**Colorado Springs, CO
Planning and Development**

Final Report - Corrections Required
Application No. DEPN-23-0002

Description : proposing to build (4) 3-story apartment buildings with clubhouse and pool

VETERANS VICTORY - LOT 1 DEVELOPMENT PLAN

Z:\0001-Dakota Springs\02-Waterview Partners\19-05-Waterview North Site\04-VeteransVila\CAD\Plans\Development Plan - Apartments\19-05-05-Waterview North Site\04-VeteransVila\CAD\Plans\Development Plan - Apartments\19-05-05-Waterview North Site - Detailed Grading [North].dwg

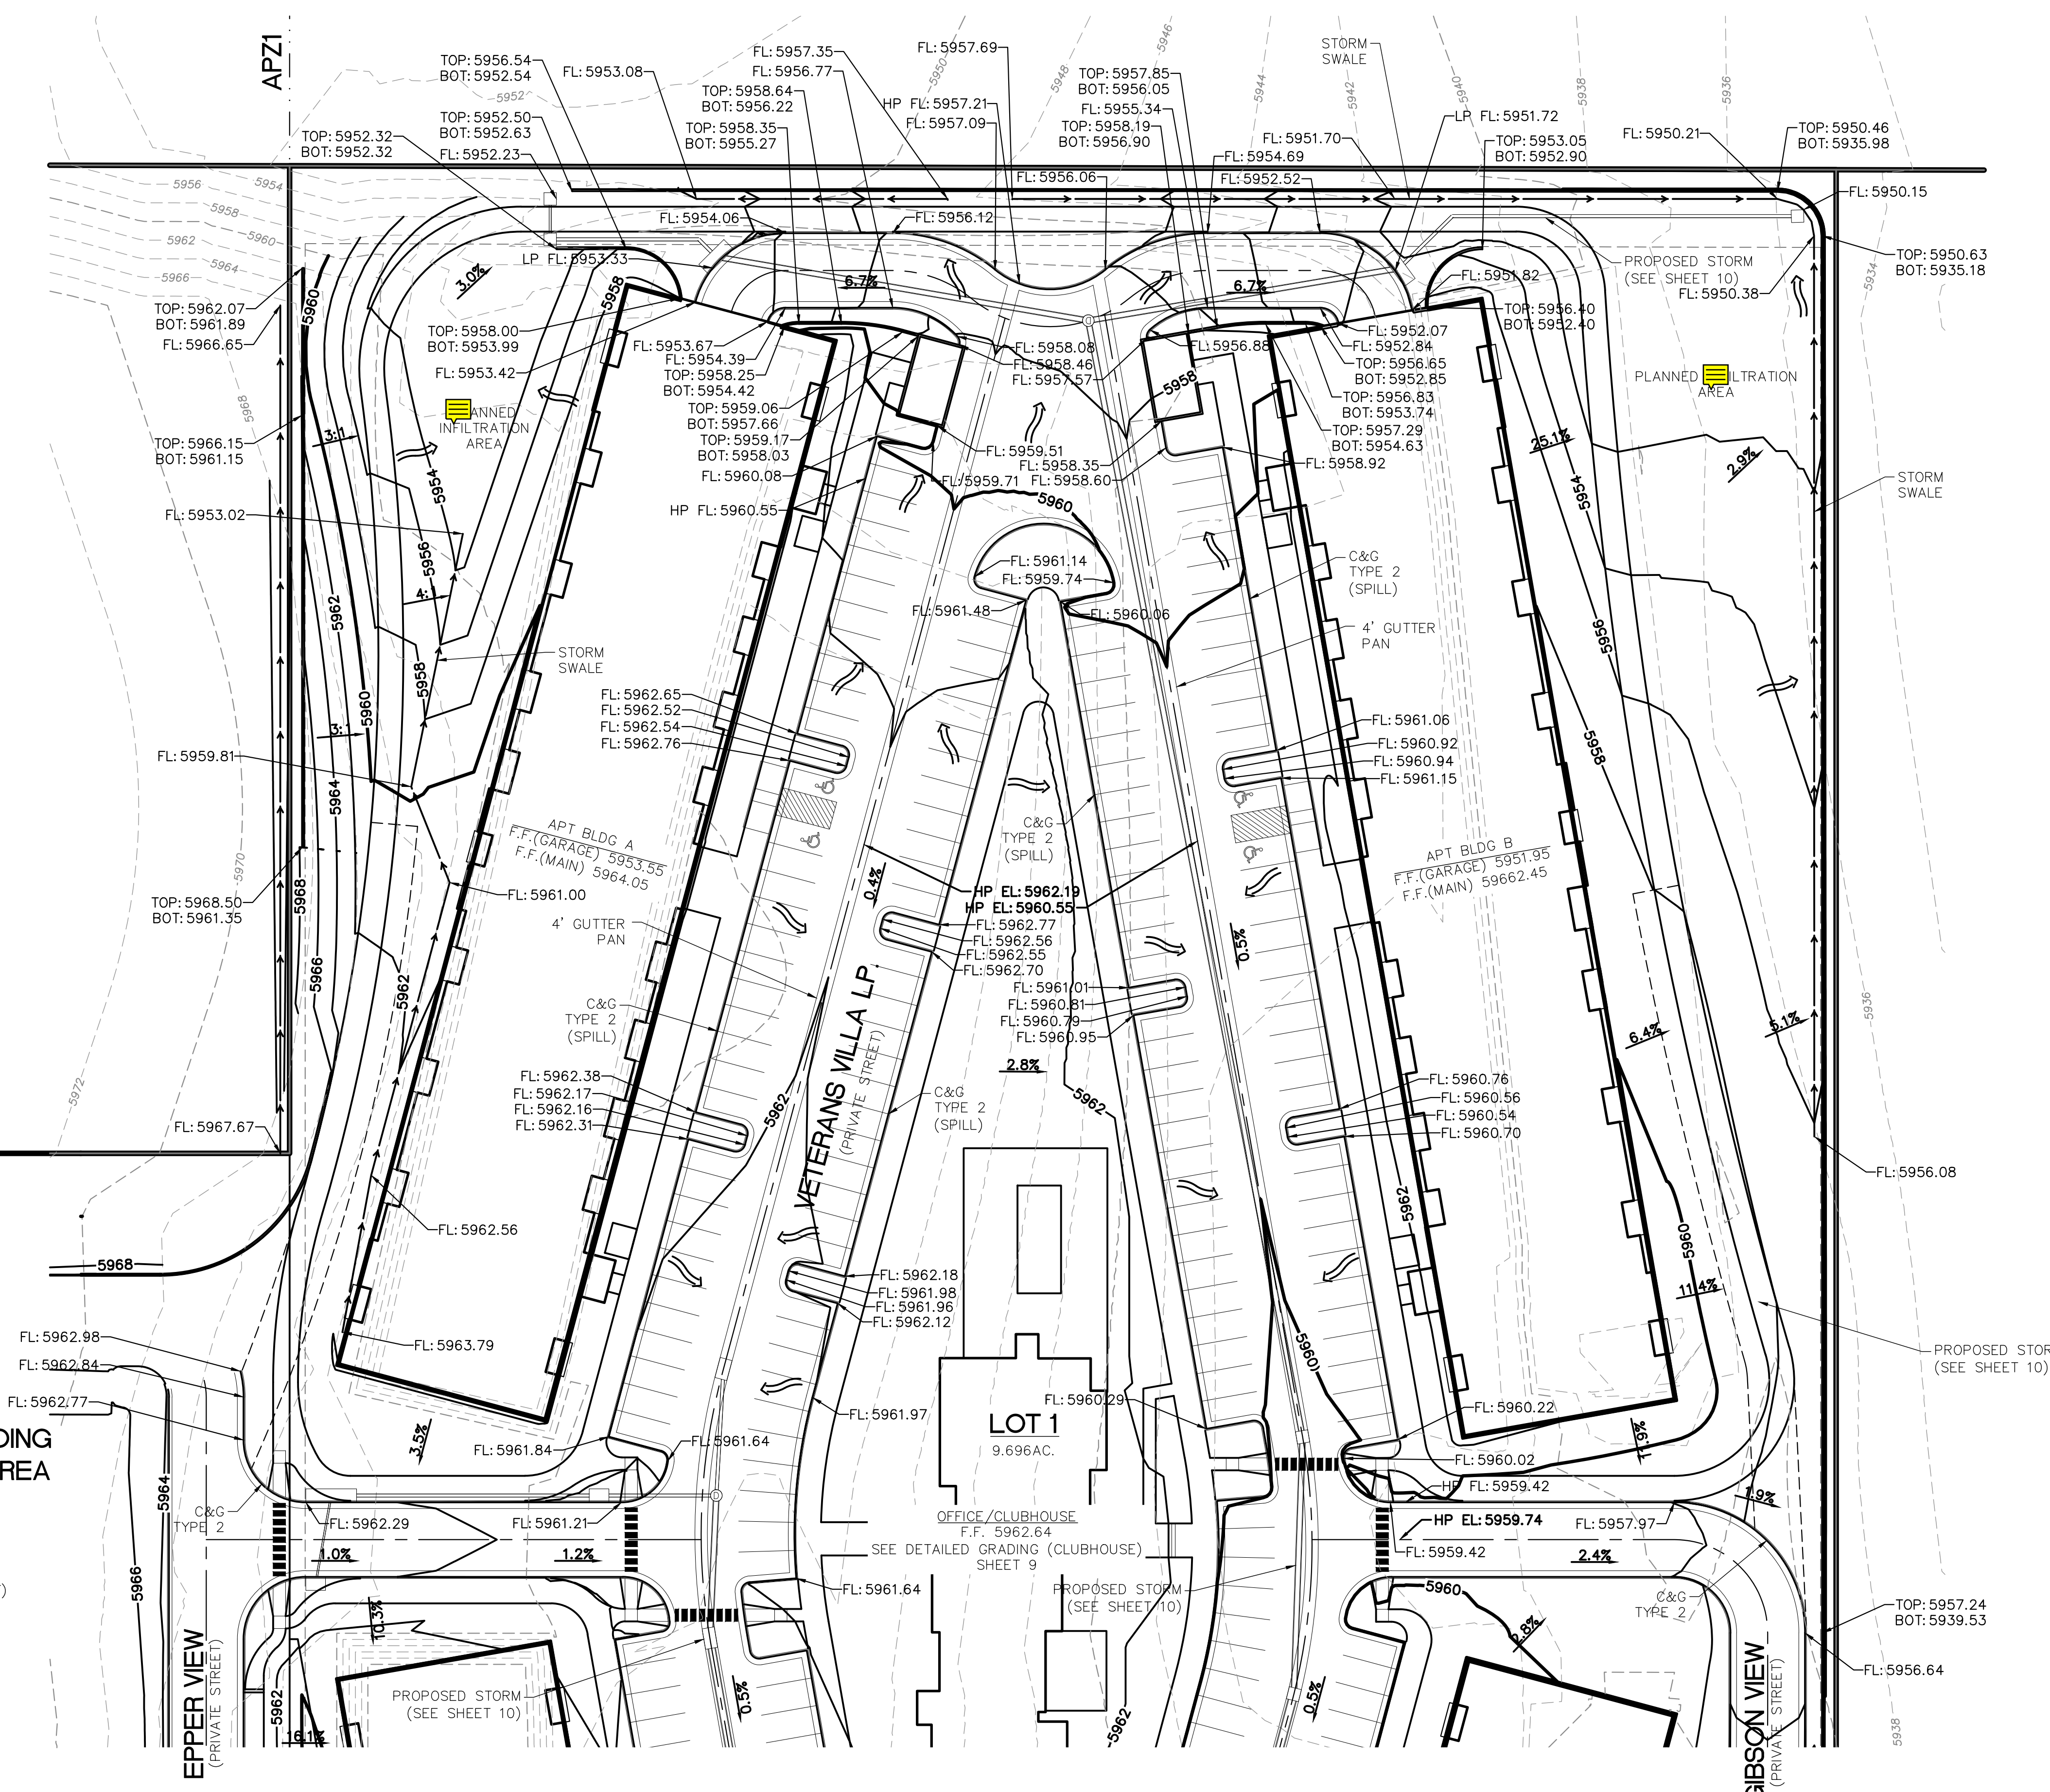
55	5	TJ Gajda : City Engineering - SWENT	Please show pipe infrastructure (pipes, MH, inlets) on grading sheets. It can be labeled on other sheets, but needs to be shown here.
47	6	TJ Gajda : City Engineering - SWENT	Please show pipe infrastructure (pipes, MH, inlets) on grading sheets. It can be labeled on other sheets, but needs to be shown here.
58	6	TJ Gajda : City Engineering - SWENT	Any trash enclosures cannot be placed this close to stormwater inlets. Please move any enclosures that are near an inlet.
61	6	TJ Gajda : City Engineering - SWENT	Label swales (all)
56	7	TJ Gajda : City Engineering - SWENT	Please show pipe infrastructure (pipes, MH, inlets) on grading sheets. It can be labeled on other sheets, but needs to be shown here.
62	7	TJ Gajda : City Engineering - SWENT	Please show pipe infrastructure on grading sheet. It can be labeled on other sheets, but needs to be shown here.
63	7	TJ Gajda : City Engineering - SWENT	Label swales (all)

65	7	TJ Gajda : City Engineering - SWENT	Is there a swale to get flows to go to this inlet? (not shown)
41	8	TJ Gajda : City Engineering - SWENT	Add MH types
42	8	TJ Gajda : City Engineering - SWENT	What is the pipe leaving this inlet? 42" pipe leading into it is quite large.
43	8	TJ Gajda : City Engineering - SWENT	This is a very large pipe connecting to the inlet. While private pipes can use inlets as junctions, It must fit within the standard inlet (existing) without modification to meet DCM.
44	8	TJ Gajda : City Engineering - SWENT	This pipe is not labeled. It should connect to the MH.
45	8	TJ Gajda : City Engineering - SWENT	What is the purpose of this overflow pipe? Is there no curb capacity? The inlet must have capacity. Trench drains tend to clog more than standard inlets. Please use standard inlet with capacity and no overflow pipe.
49	8	TJ Gajda : City Engineering - SWENT	I have not seen any FDR with calculations of pipes or ponds that will receive this site's flows. I cannot do a full review without knowing that full spectrum detention and the four step process is addressed.

**VETERANS VICTORY - LOT 1**

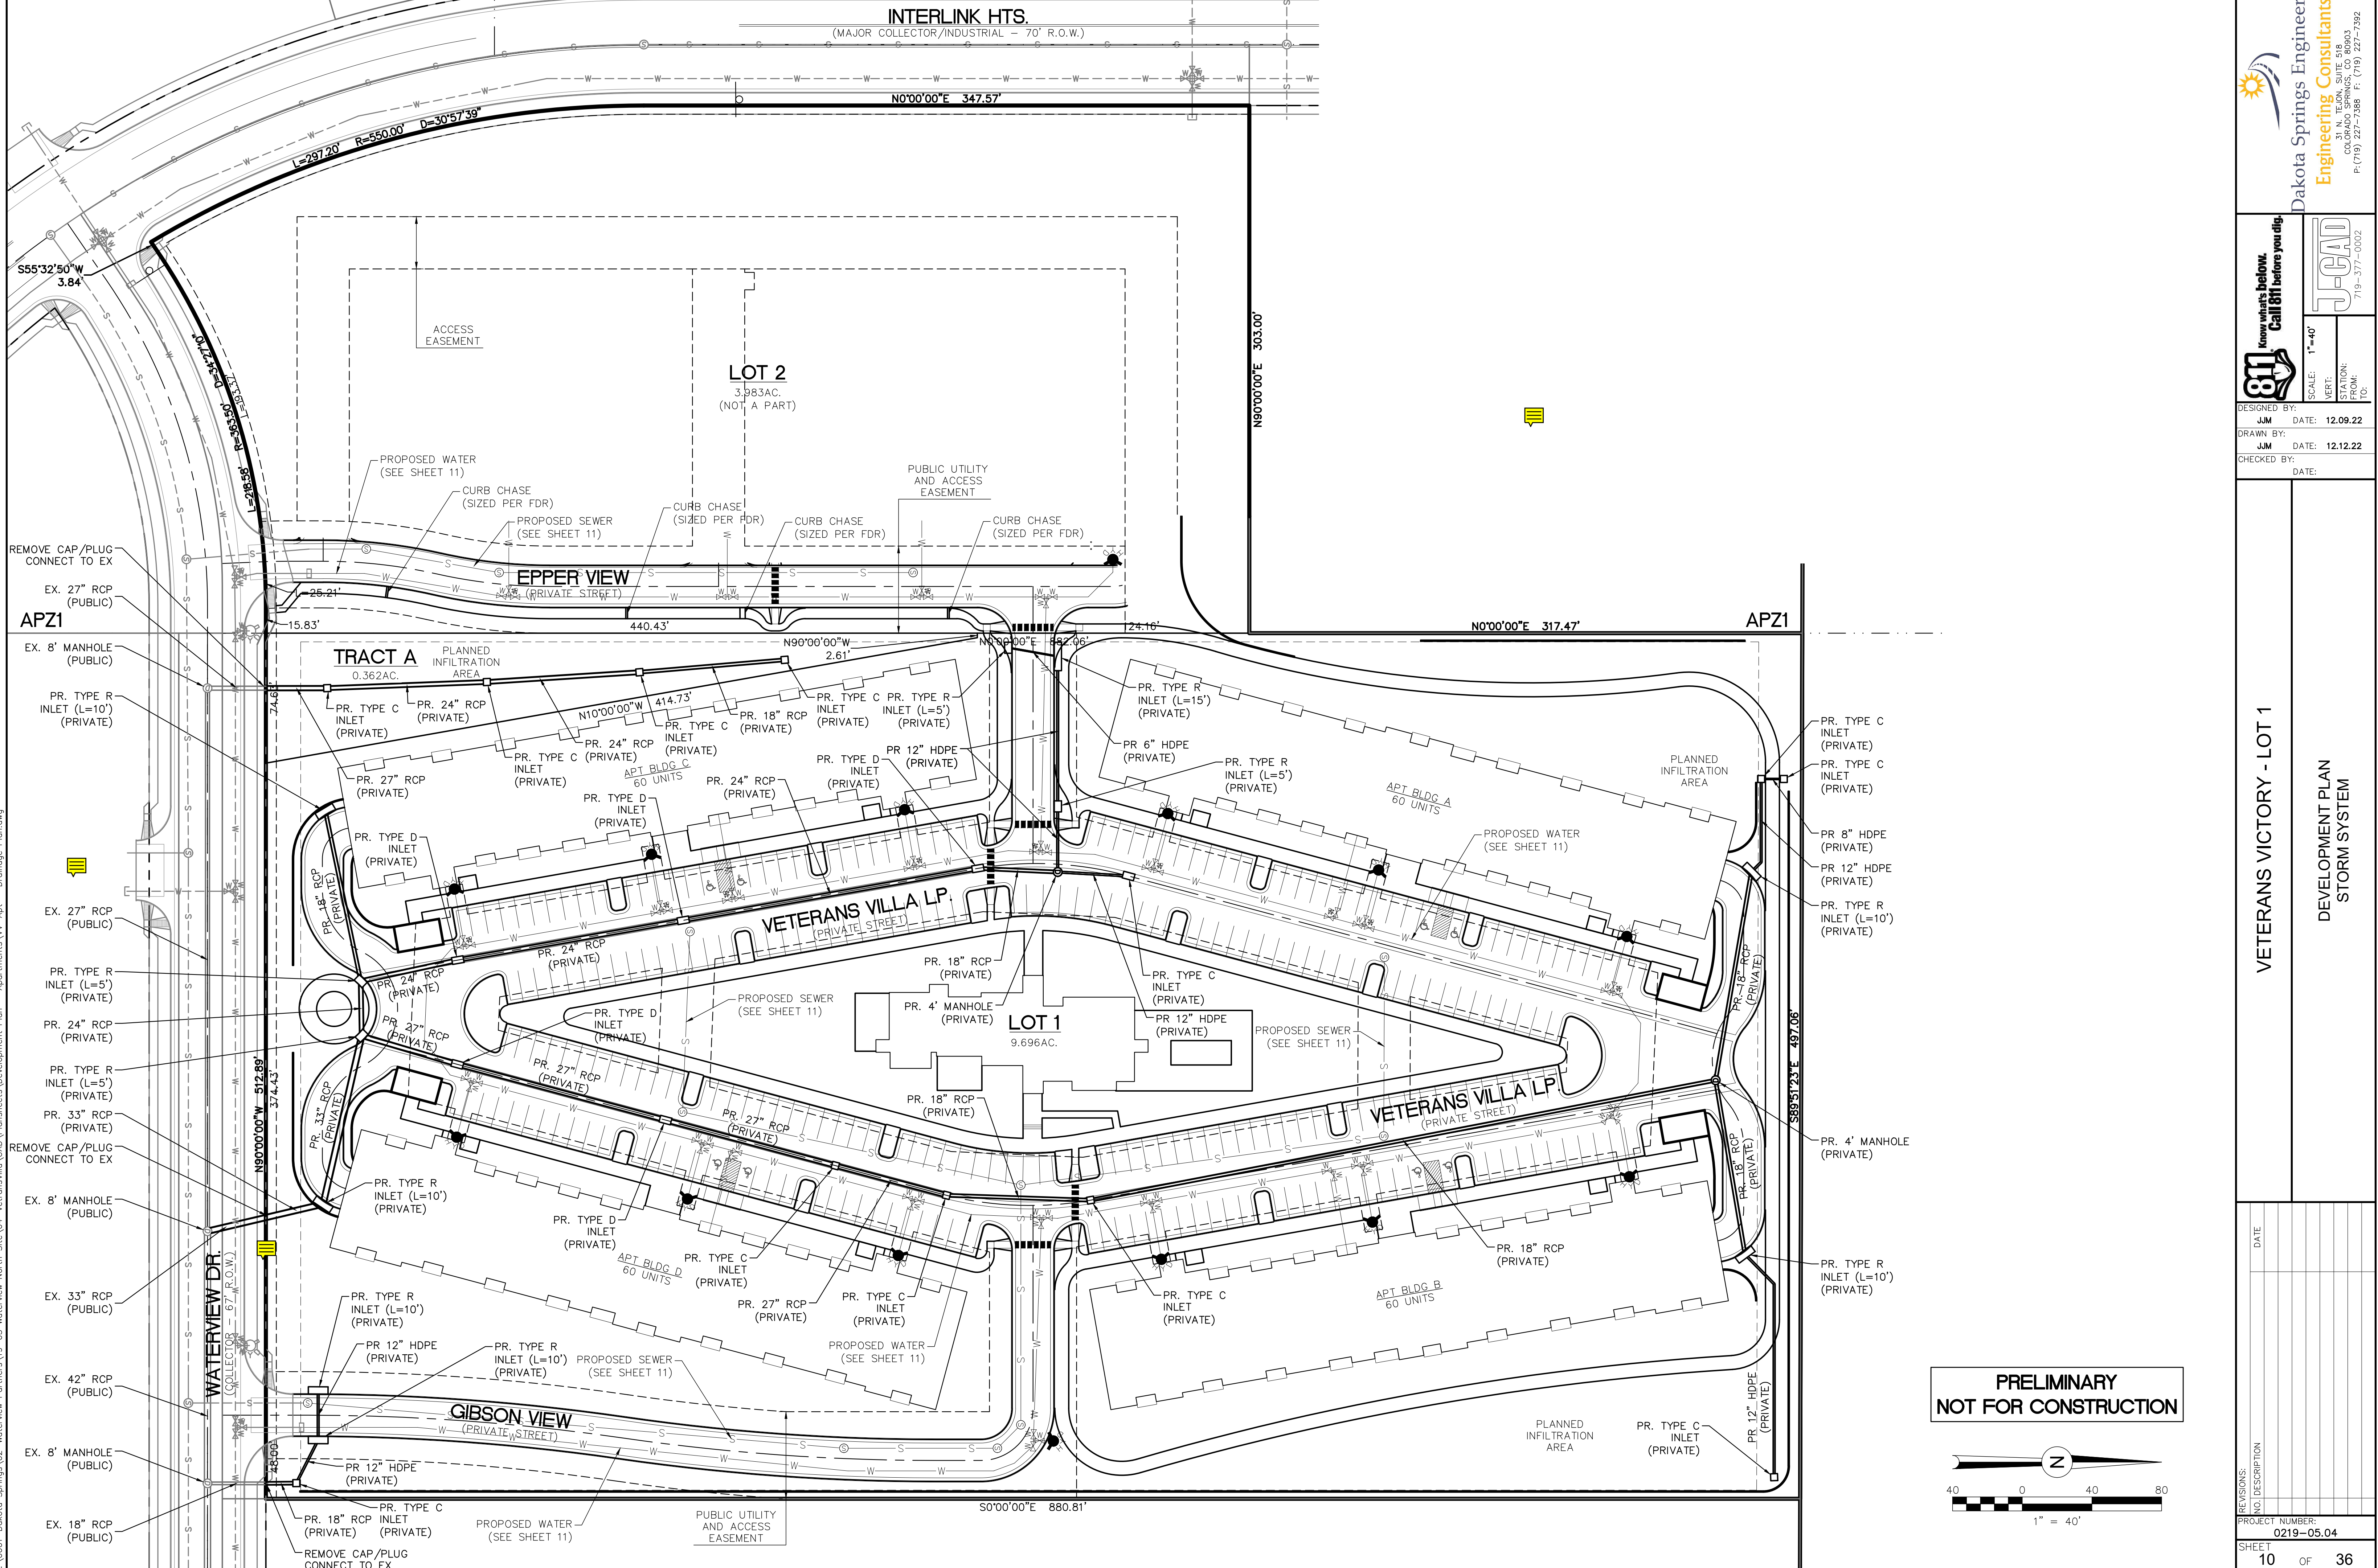
31	1	Steve Smith : Fire	What are the proposed road networks to get to this site?
35	1	Steve Smith : Fire	Provide a note on the plans that indicates all apartment buildings will be provided with an internal fire standpipe system per NFPA 14, in lieu of required hose reach around the building.
36	1	Steve Smith : Fire	Provide a fire apparatus movement exhibit showing fire apparatus driving along all roadways . Utilize the data found in this document (https://coloradosprings.gov/sites/default/files/csfd_apparatus_specifications_2023.pdf) to input into AutoTurn to generate the exhibit.
32	4	Steve Smith : Fire	Identify on the plans, all areas that will be marked as a fire lane.
33	4	Steve Smith : Fire	Remove this reference as this will not be permitted as a fire lane.
34	4	Steve Smith : Fire	Remove this reference as this will not be permitted as a fire lane.
37	8	Steve Smith : Fire	Show the proposed location of the fire department connection (FDC) for each building. Coordinate this location with the landscape plans to ensure adequate access and visibility. Also ensure a fire hydrant is provided within 100' of each FDC.

38	10	Steve Smith : Fire	Coordinate locations of fire hydrants and fire department connections with the landscape plans. There are some instances where proposed fire hydrant locations are in conflict with landscaping.
